**APPLICATION NO. LU/114/15/RES – RESPONSE TO WEST SUSSEX COUNTY COUNCIL (WSCC)
Construction of access road to north of Toddington Lane, east of proposed Southern Lyminster
Bypass and west of Parcels B3 and B5
Land North of Toddington Lane, Littlehampton, West Sussex, BN17 7PP**

I refer to the above application and to the comments received from WSCC dated 28 July 2015. I confirm that the project team has reviewed WSCC's comments and I set out our responses below:

Drawing No.	CV8140927/600-1	Rev	P2
-------------	-----------------	-----	----

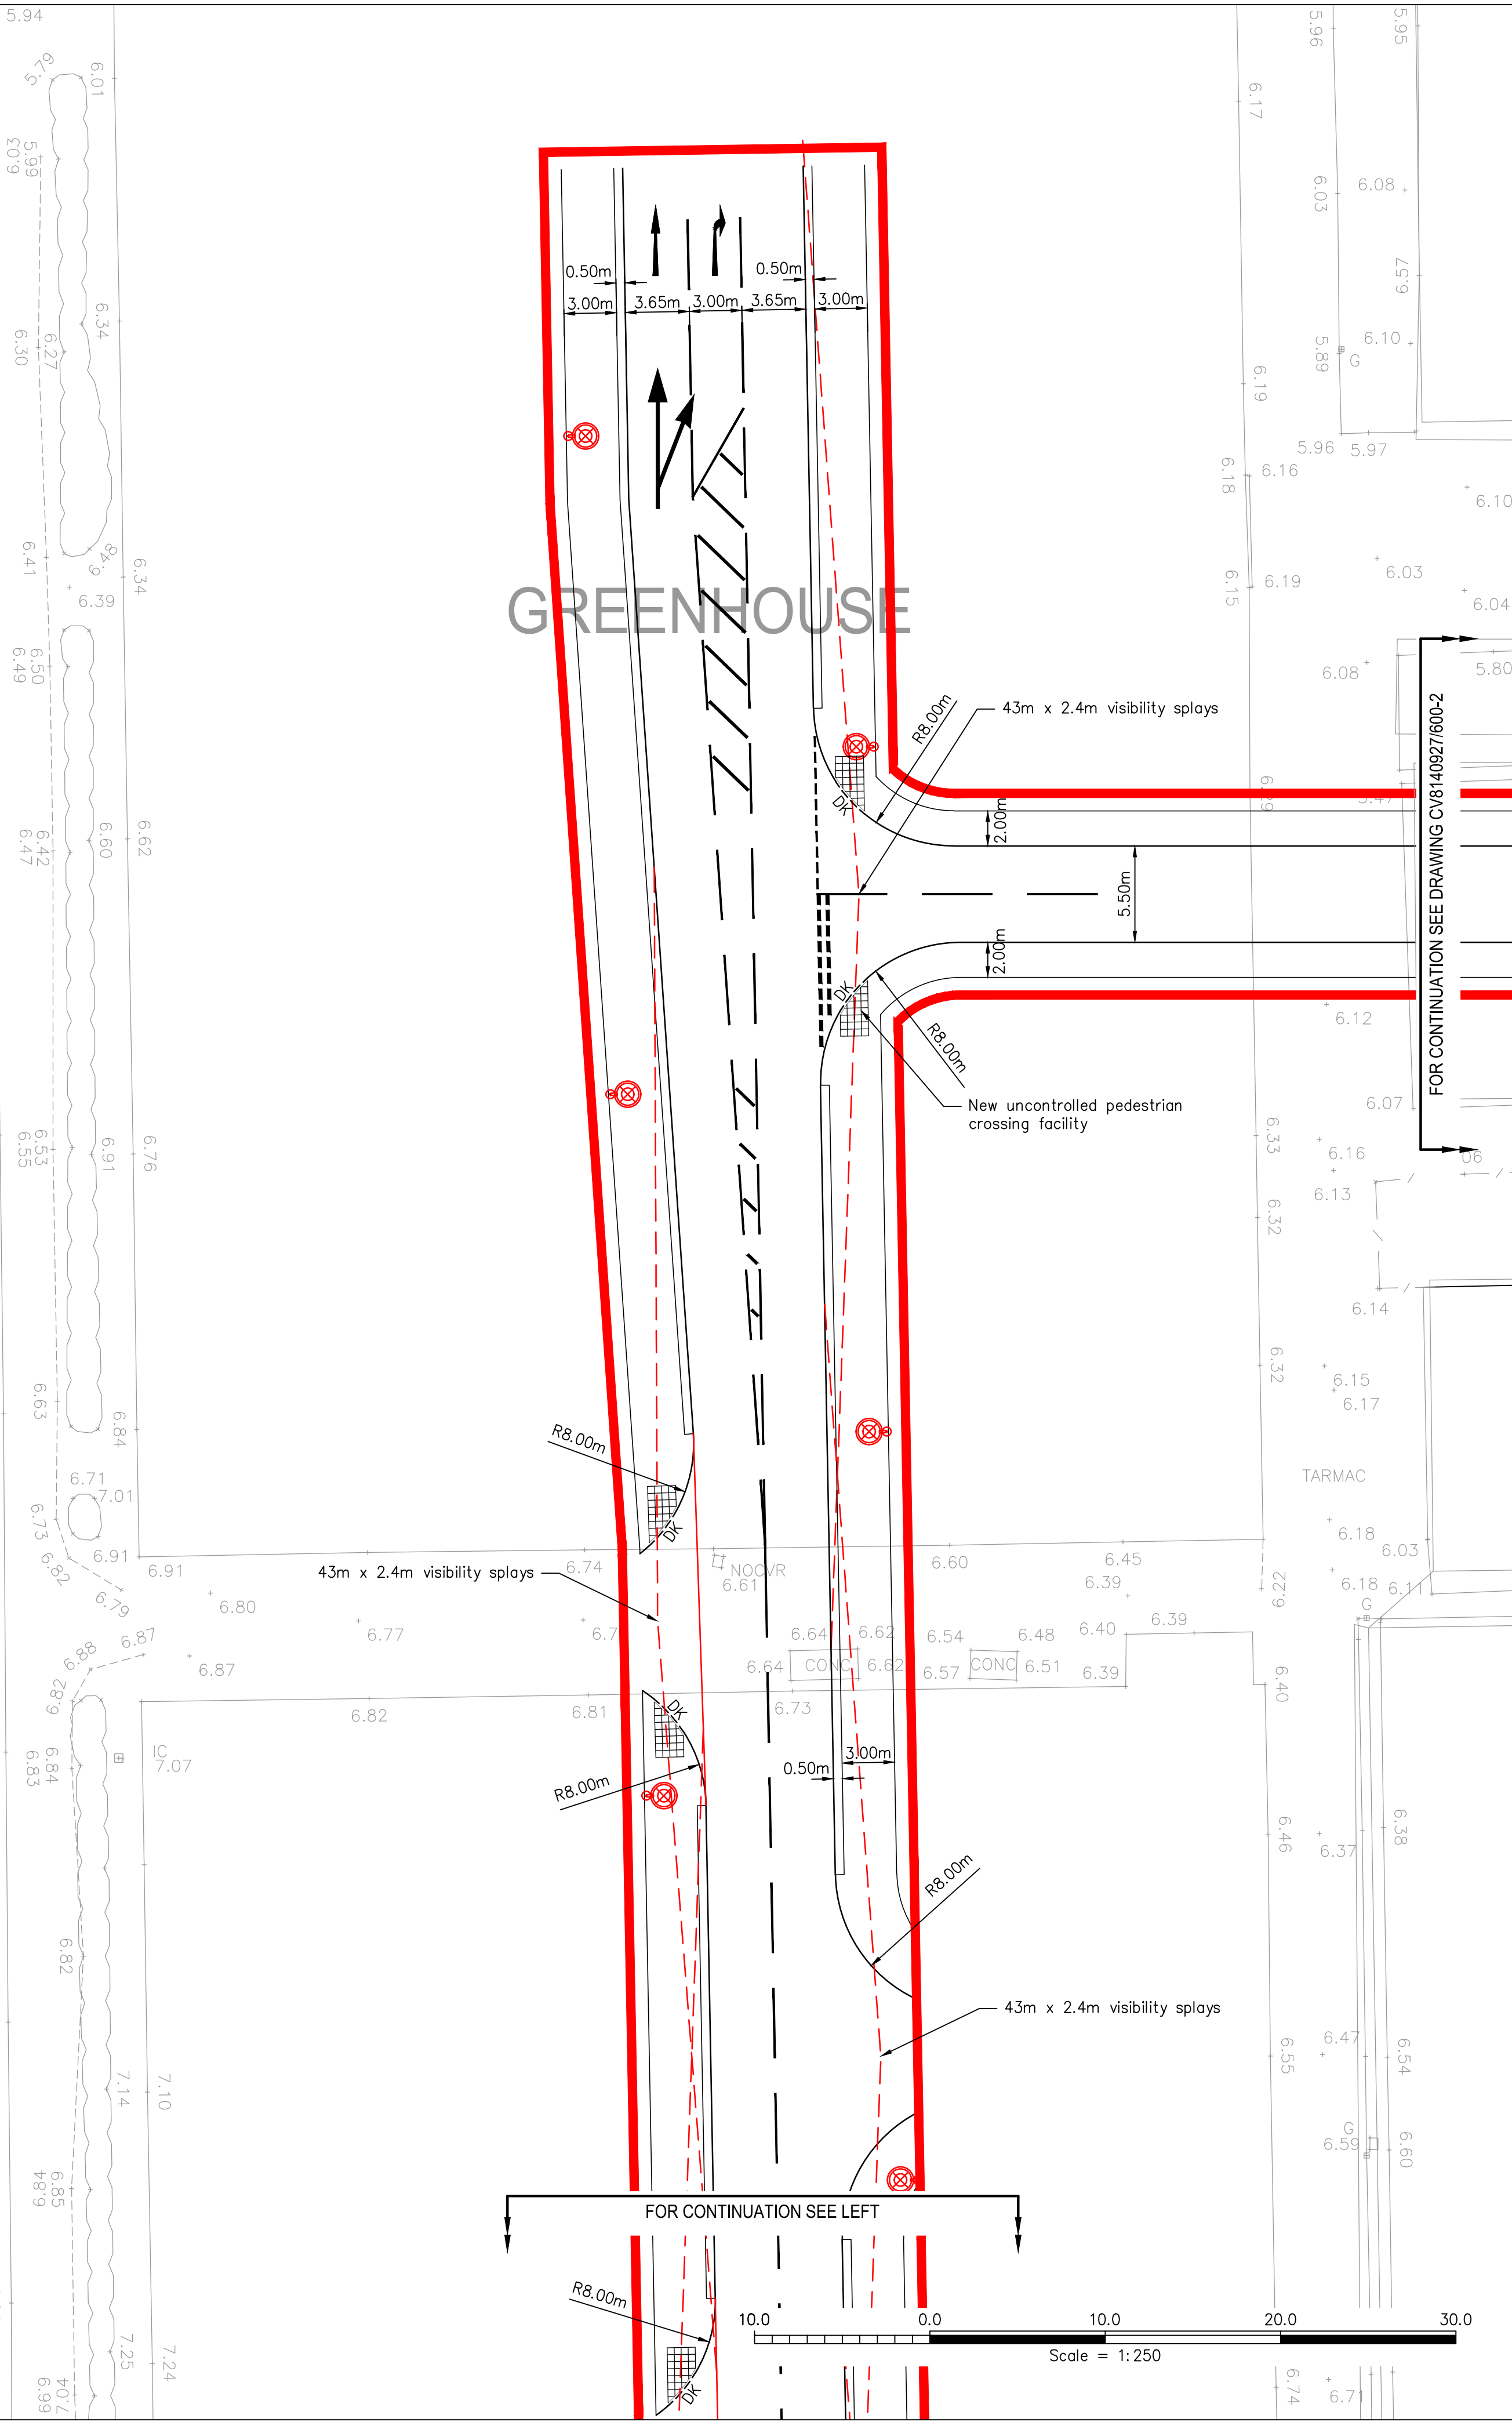
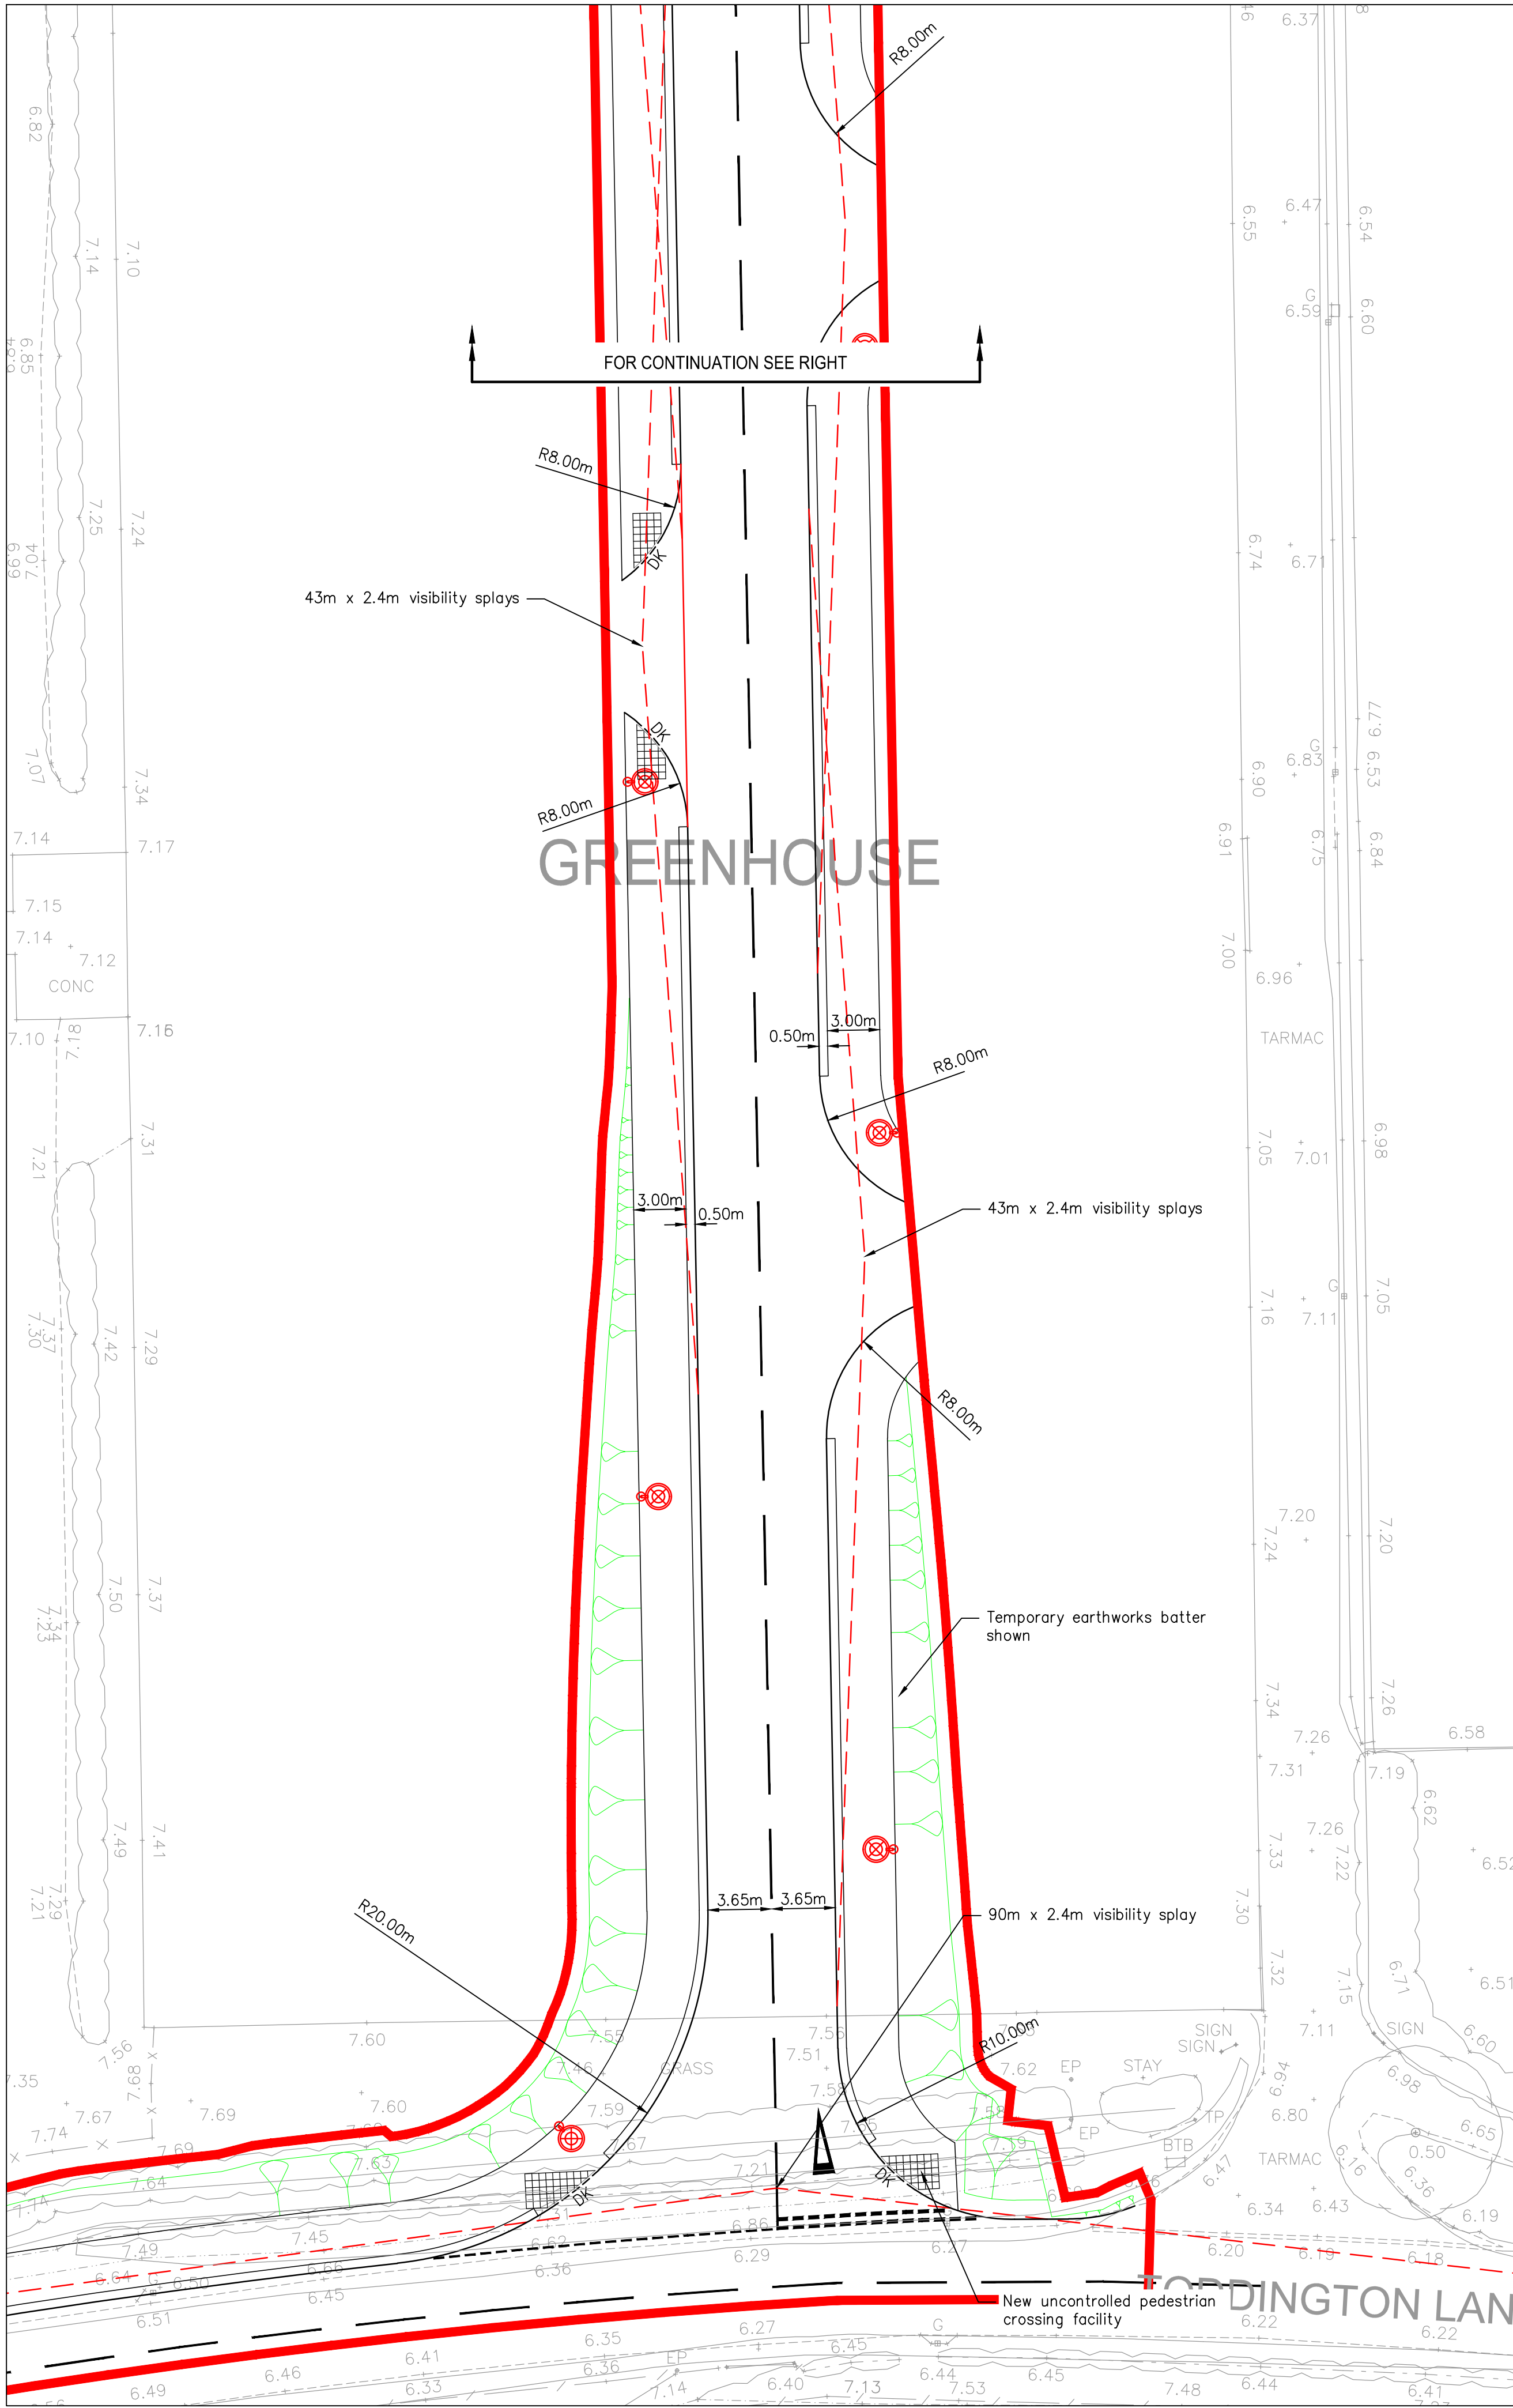
The full extent of the sight line splay in the trailing traffic direction (looking east) at the southern end of the access spine road with Toddington Lane is shown on the previously submitted plans (CV8140927/600-1). The splay on this side is cut short given that it is only constructed to the tangent of the curve on the channel line in accordance with normal best practice and the requirements of Manual for Streets and the DMRB.

Drawing No. TR8140927/SK10	Rev -
----------------------------	-------

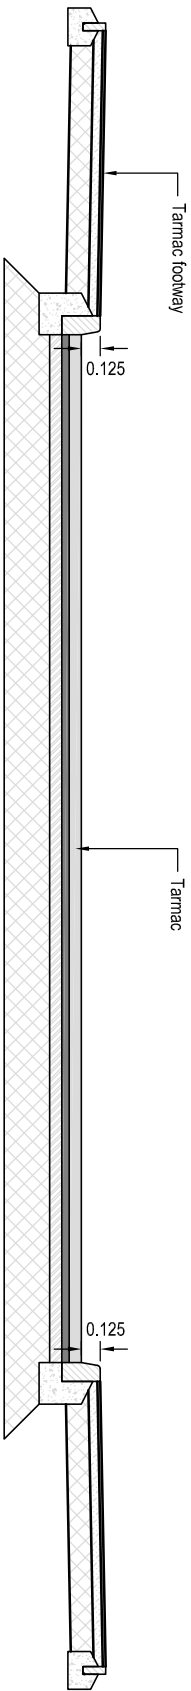
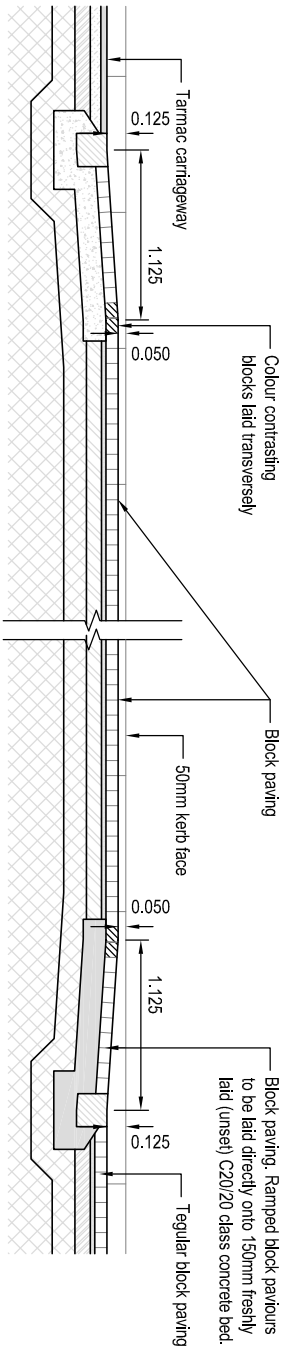
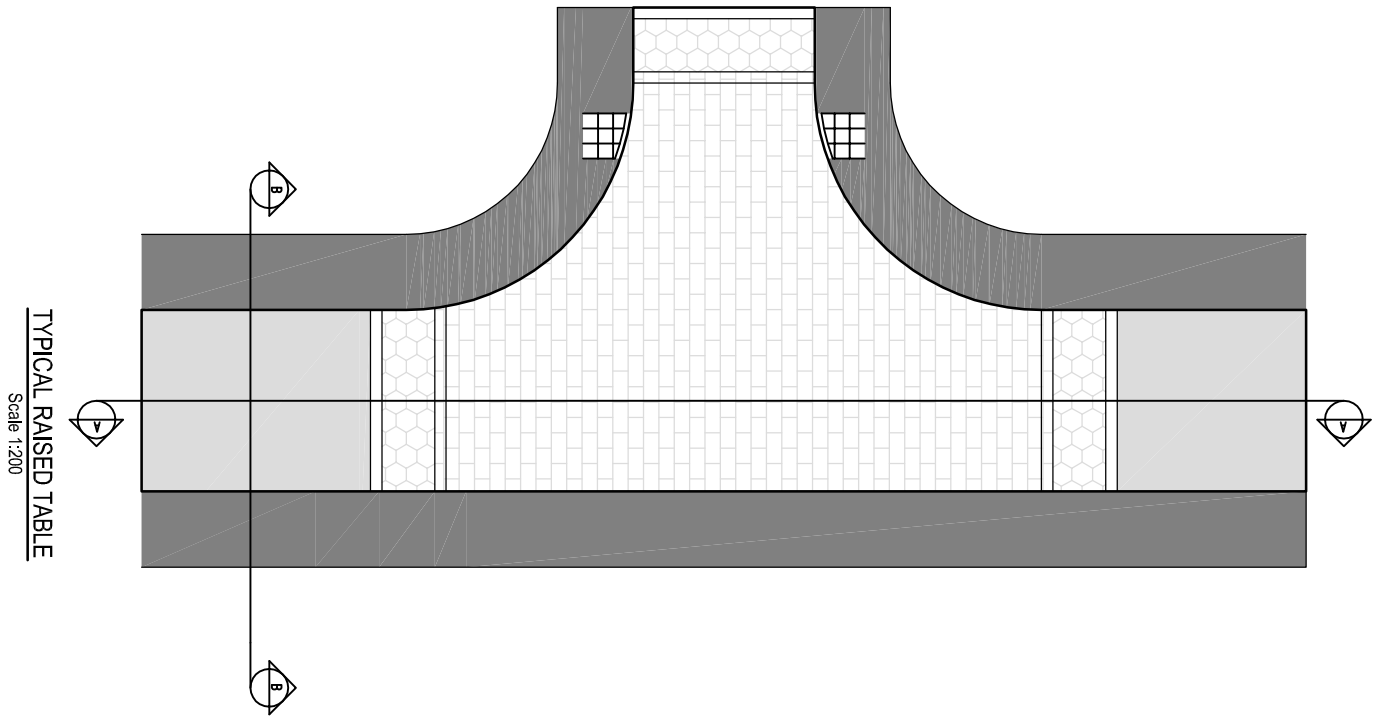
The previously submitted Drawing No. CV8140927/SK10 is in accordance with WSCC's details for the height of the road tables and already indicates a table height of 75mm. The dimension of 50mm is the retained kerb face at the location of the table top (i.e. the standard 125mm kerb minus 75mm raised table).

As in relation to Point 4 above, the previously submitted detail on Drawing No. CV8140927/SK10 (see attached) shows the table height at 75mm in accordance with the WSCC standard construction details.
